EROSION CONTROL AND GRADING PLAN

SUPERSTAR CARWASH

MEADOWBROOK PKWY

SHEET LIST TABLE	
SHEET NUMBER	SHEET TITLE
E1.0	COVER SHEET
E2.0	EROSION CONTROL PLAN
E2.1	EROSION CONTROL DETAILS
E3.0	GRADING PLAN
E3.1	RAIN GARDEN

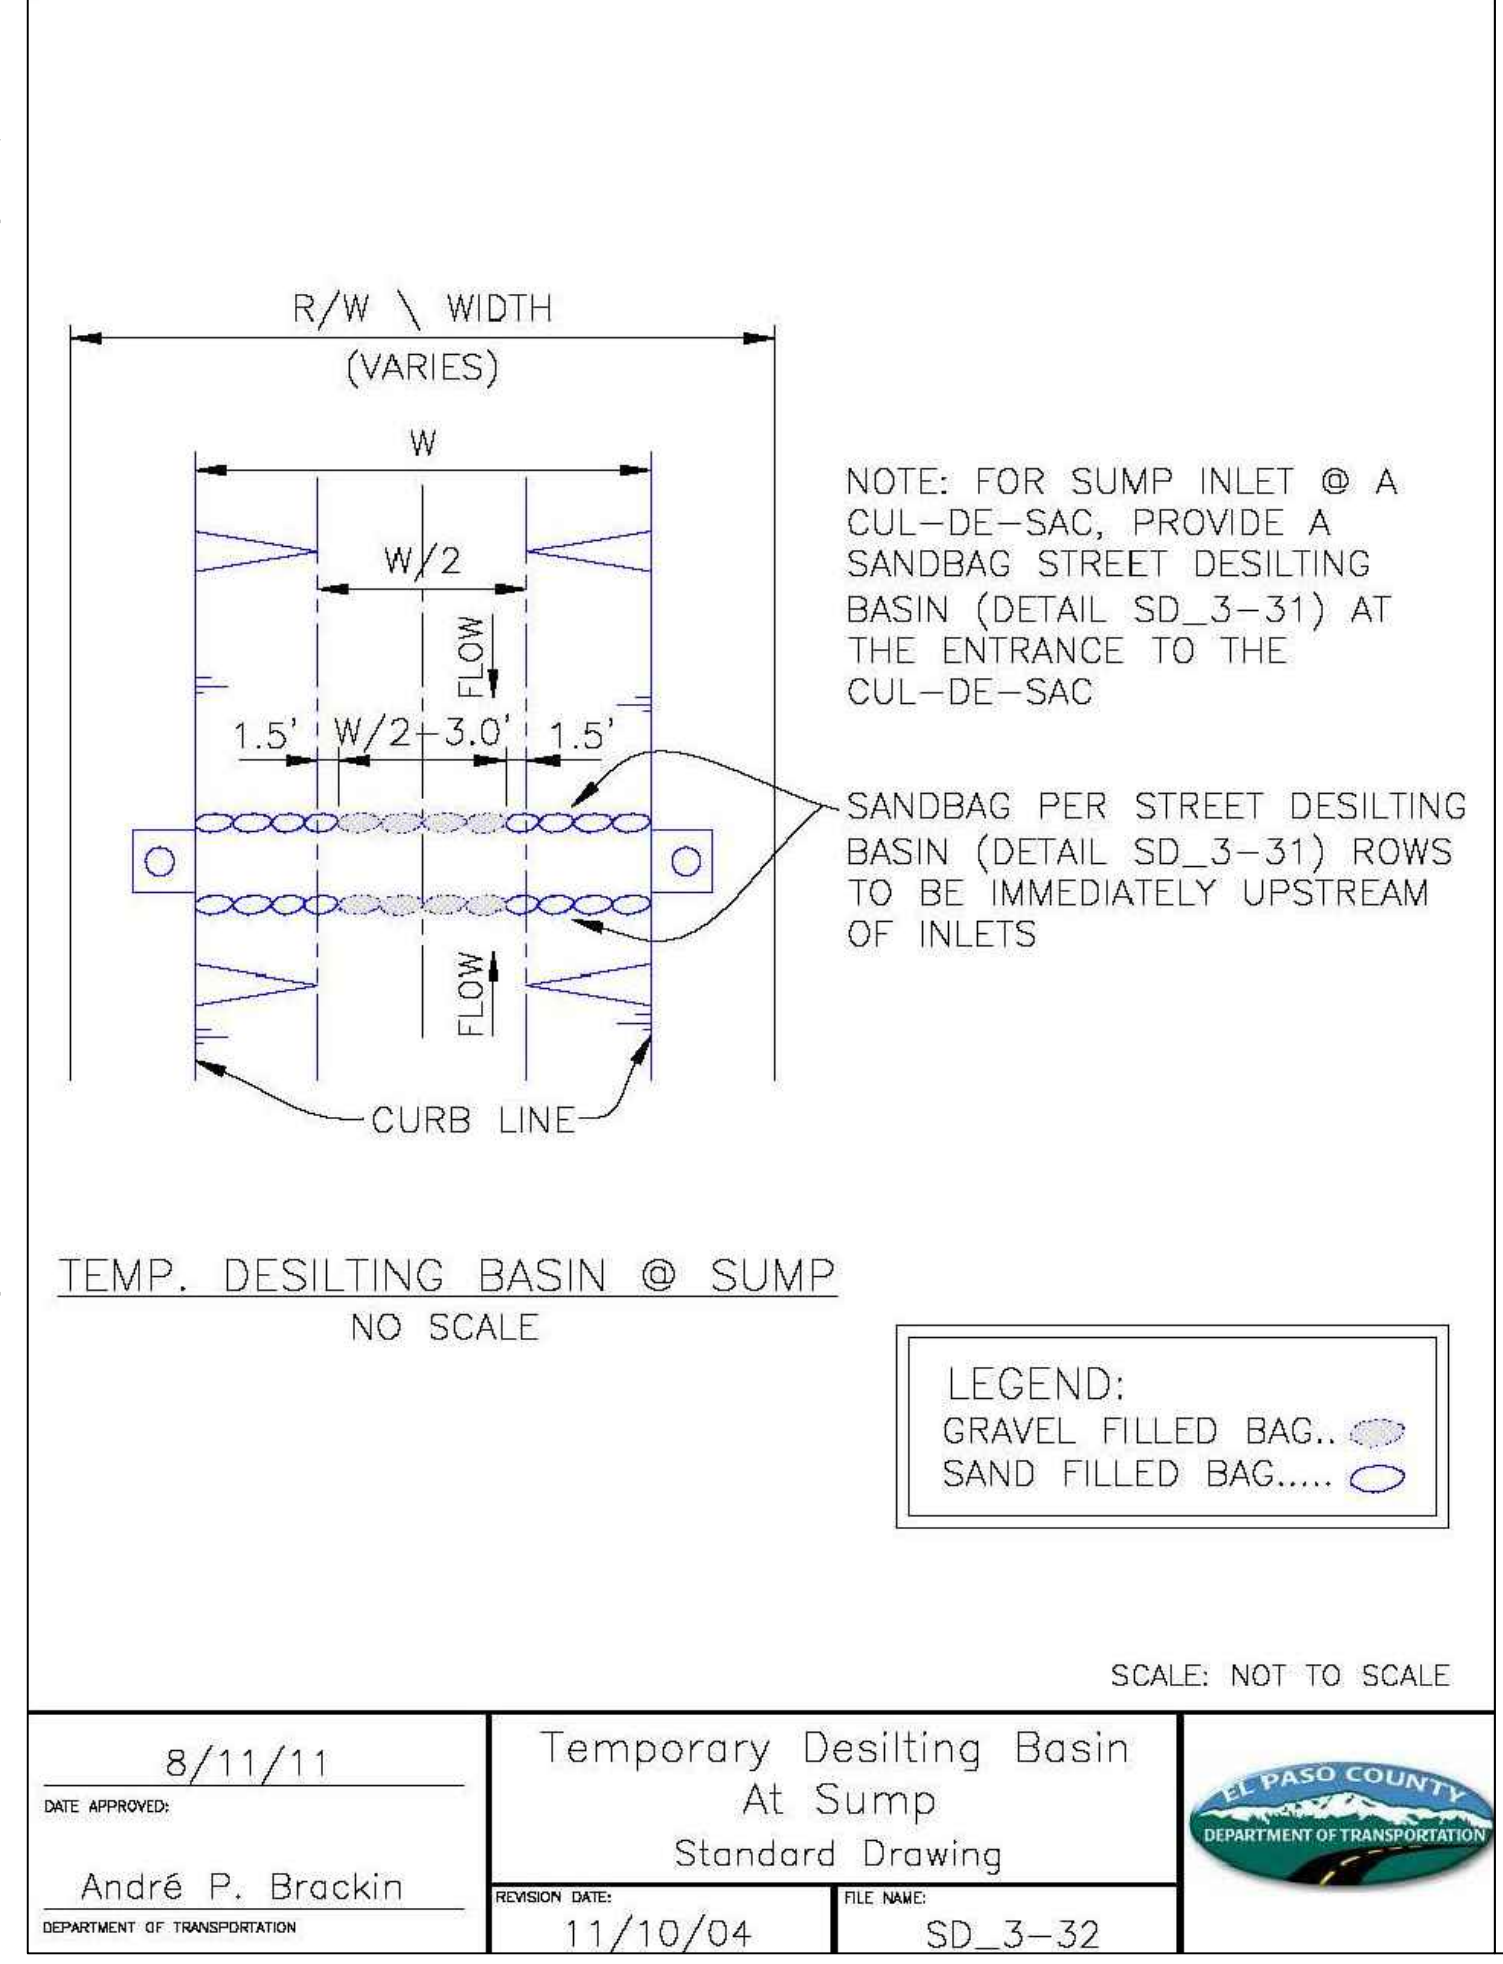
Unresolved from Submittal 2 - GEC Checklist item z: -Add temporary sediment basin details. The below desilting basin is specifically for a street sump, and is not applicable for this project site.
